From: Sue Howell
Sent: 12 December 2017 16:45
To: Claire Potts
Subject: FW: Planning Consultation on: BE/113/17/RES

APPLICATION **BE/113/17/RES**

Site Address: Land West of New Barn Lane Bersted

Approval of r
BE/113/17/RES
reserved matters following outline consent
BE/18/17/PL for appearance, landscaping, layout
& scale for a mix of up to 90No. residential units,
associated open space, landscaping, access &
car parking

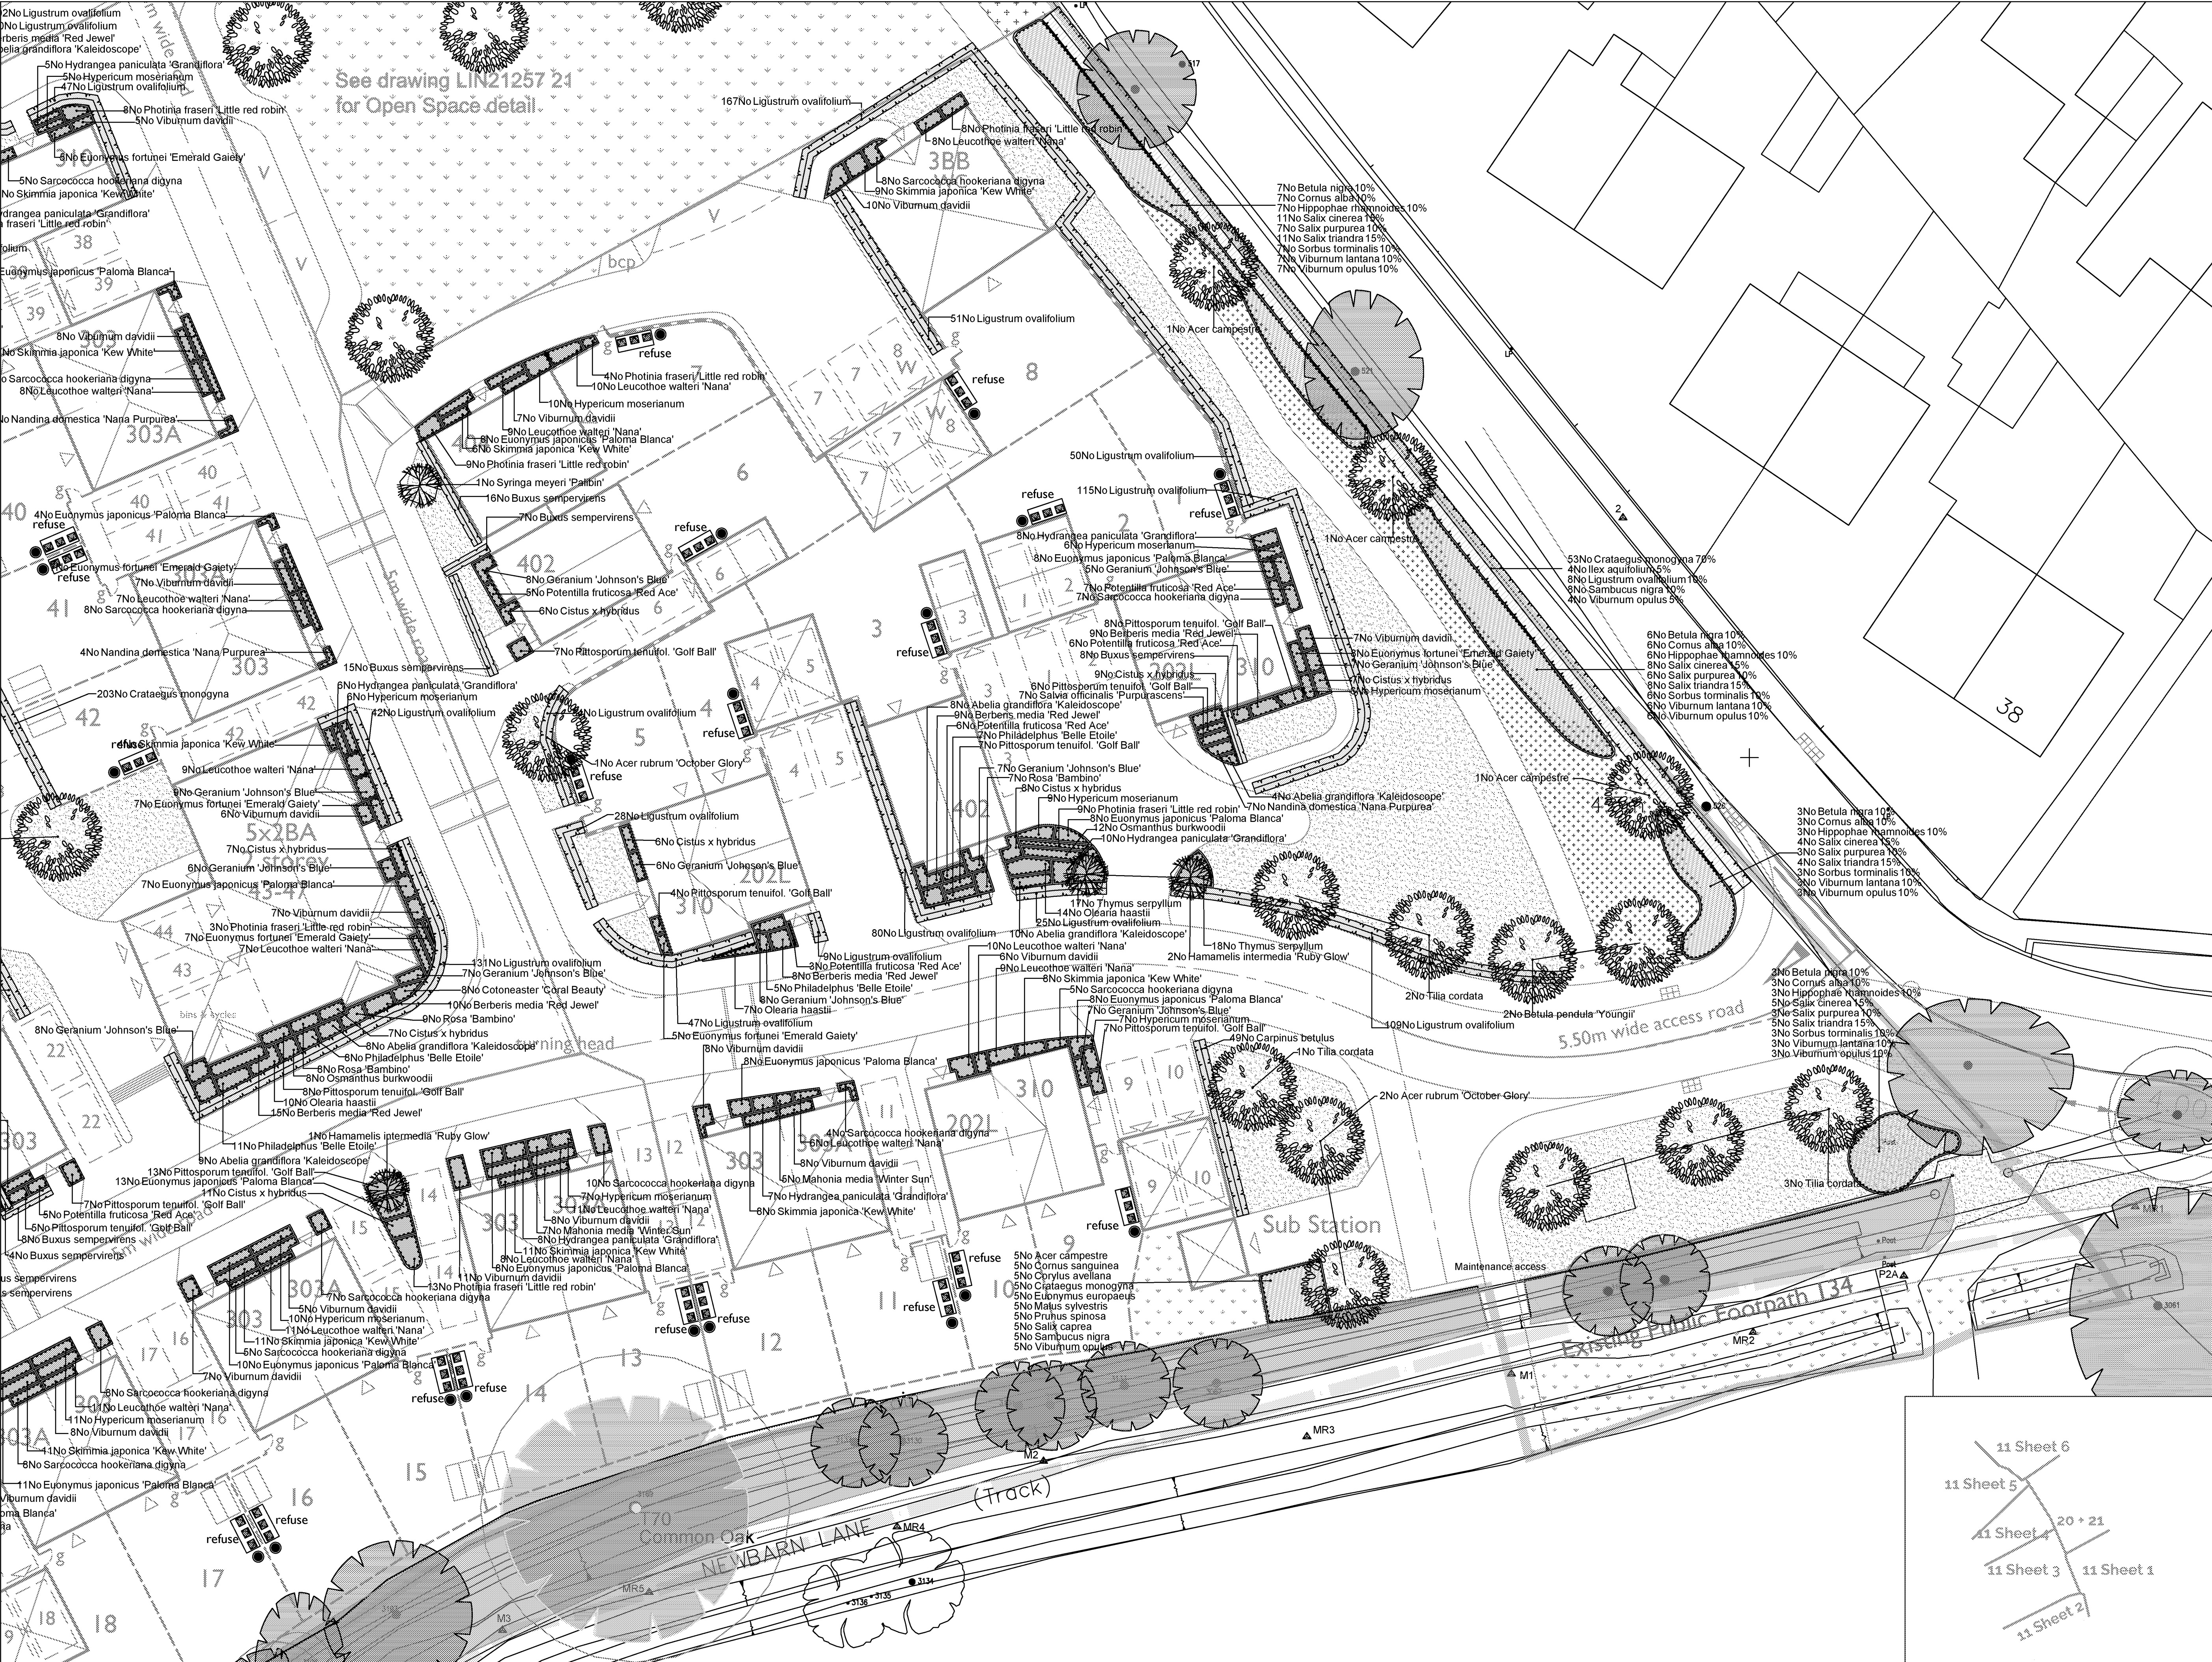
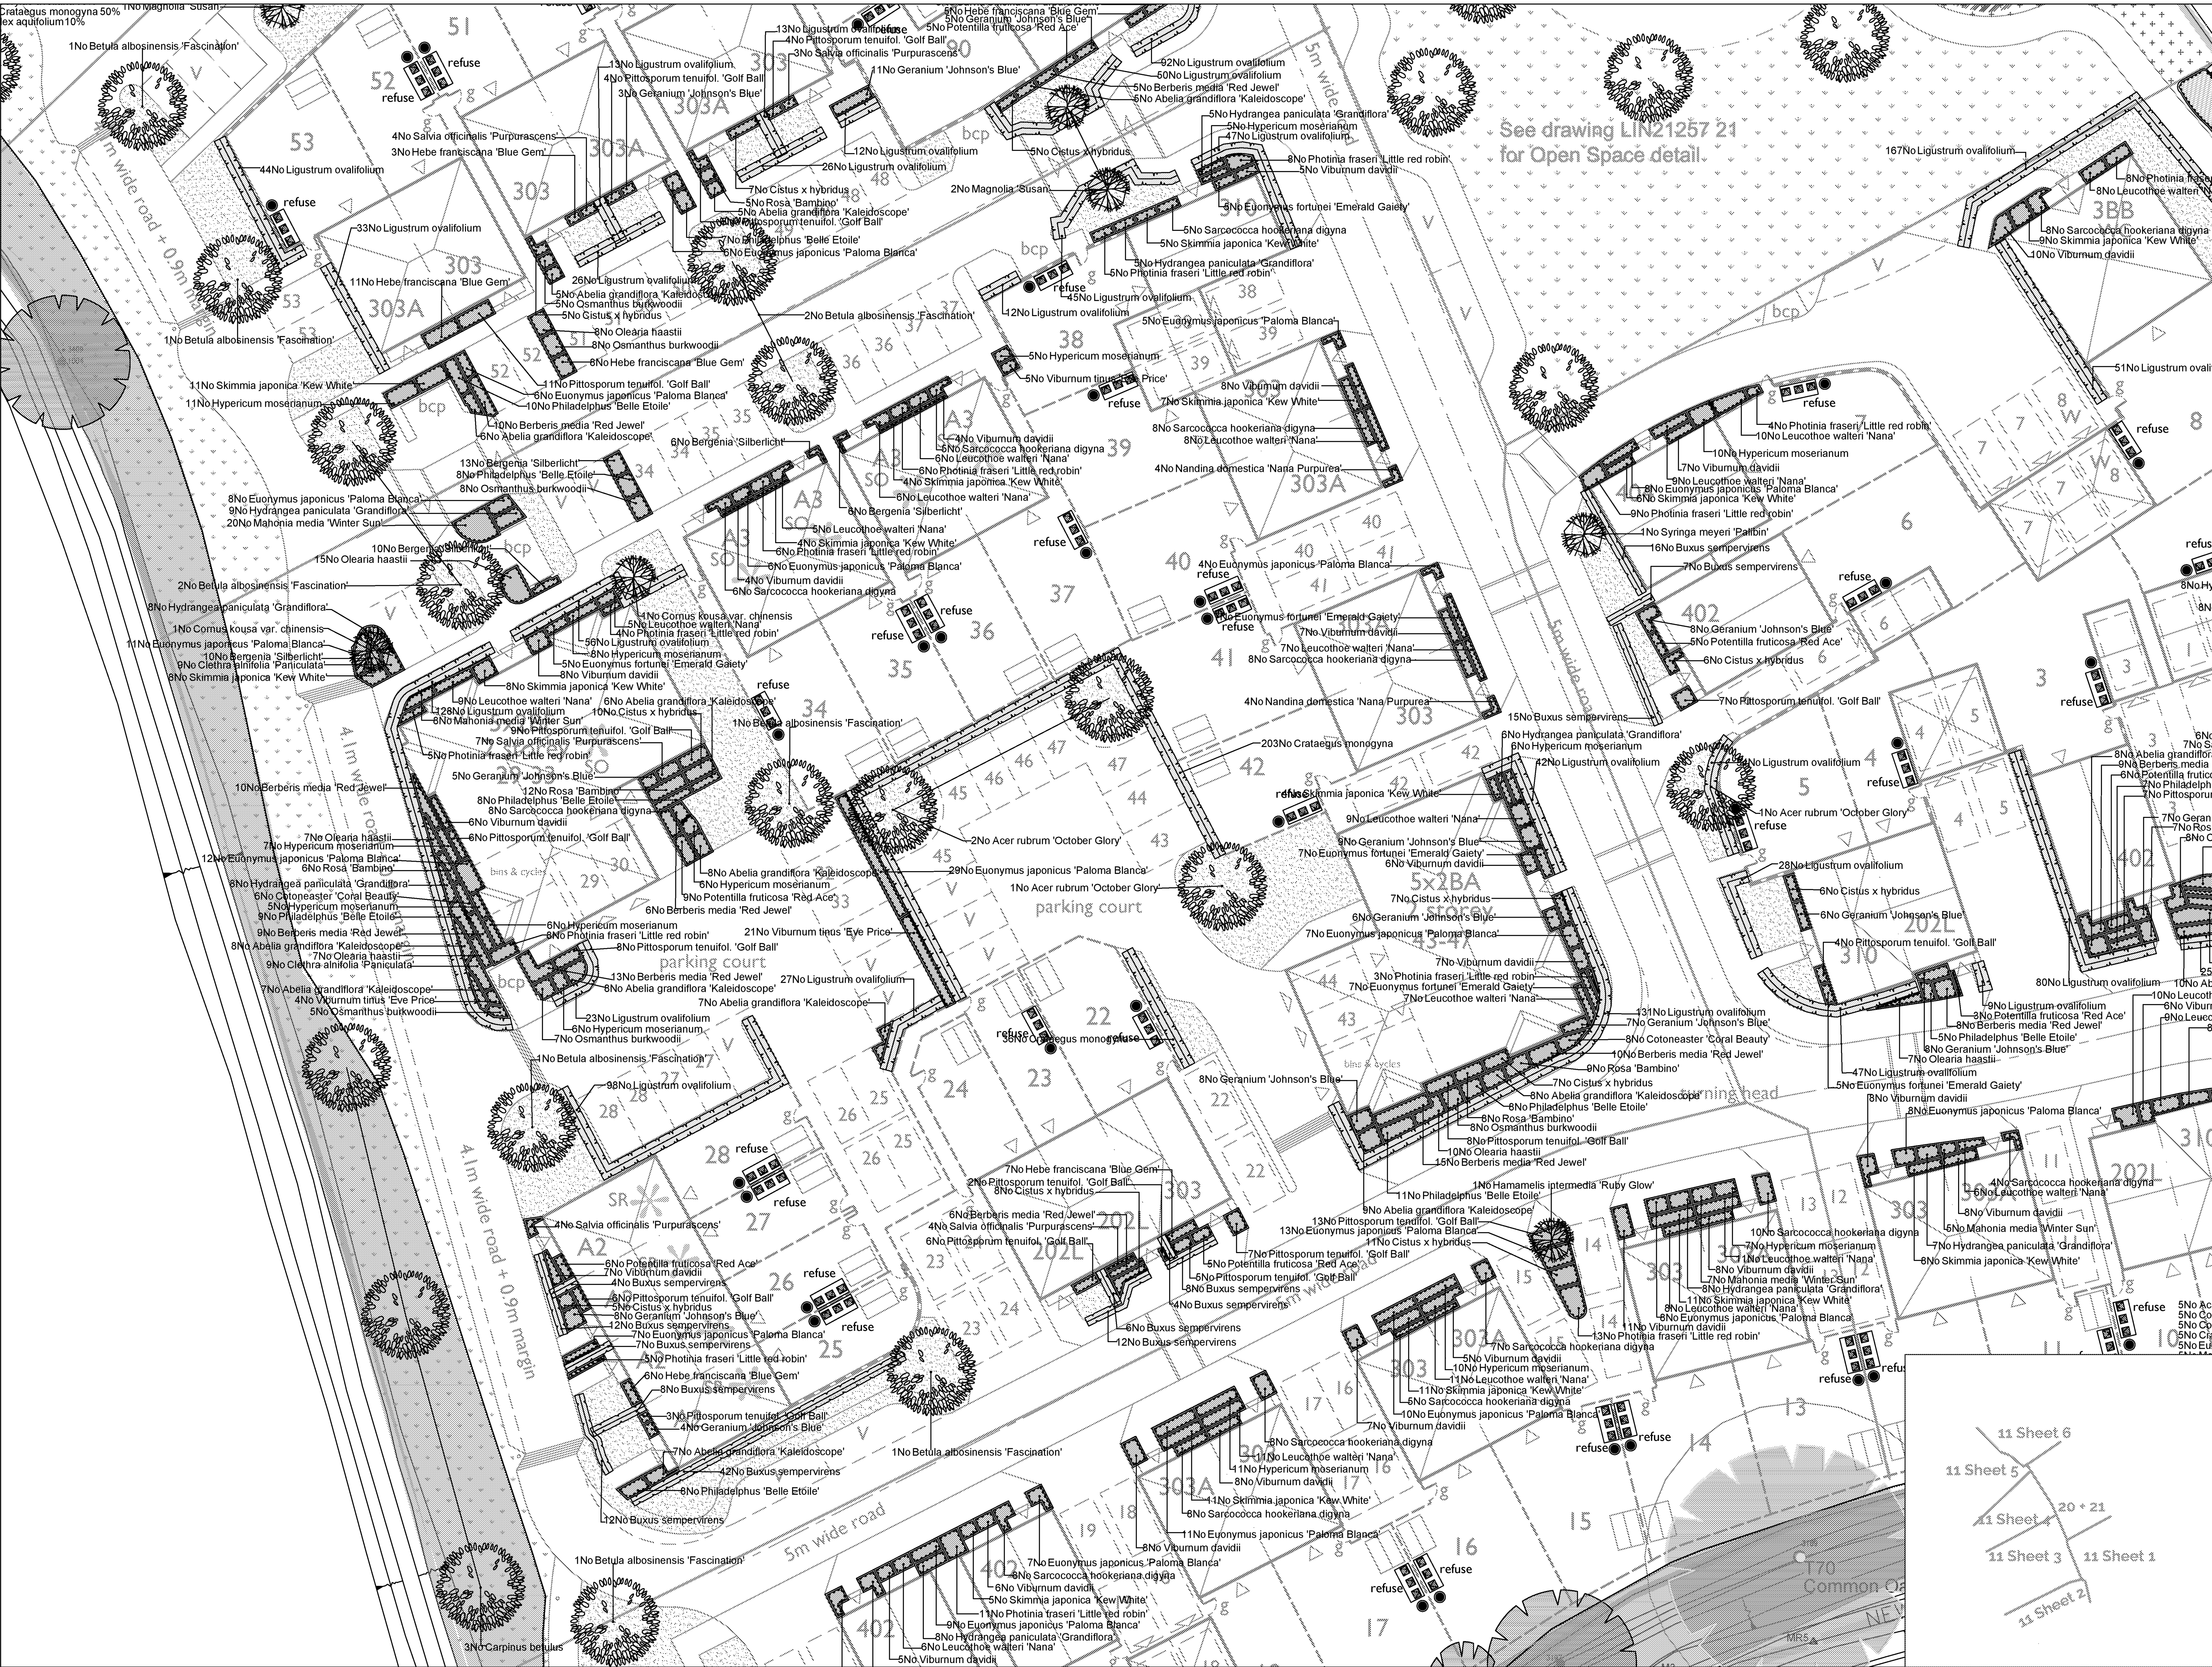
The play areas LEAP and 2 x LAP are now sited very closed to a detailed swale/water body. We would require clarification of the proximity of these to this drainage facility also to the depth of this indicated swale? The previously submitted detail indicated the main basin depth of 500mm, with 1000mm to the basin ditch only. The levels now shown would appear to indicate that this is now proposed to be significantly deeper than this with steeply angled sides? Please confirm the proposed levels of the swale, site sections sheet 2 16-1103-006 shows sections which stop short of this area, section E/E needs to extend through the play area and the proposed swale. Please also confirm the anticipated water holding period for this drainage facility?

The indicated play areas are also dissected now by the swale which is not desirable as these play open space areas would not have easy connectivity. RoSPA should be consulted regarding the suitability of the play spaces in relation to this potential standing water body.

- * Open space area proposed now significantly reduced by potential standing water body resulting in inadequate quantity of useable Public Open Space, confirmation of areas required.
- * Cross sections required to detail the proposed depth of swale and proximity to play areas.
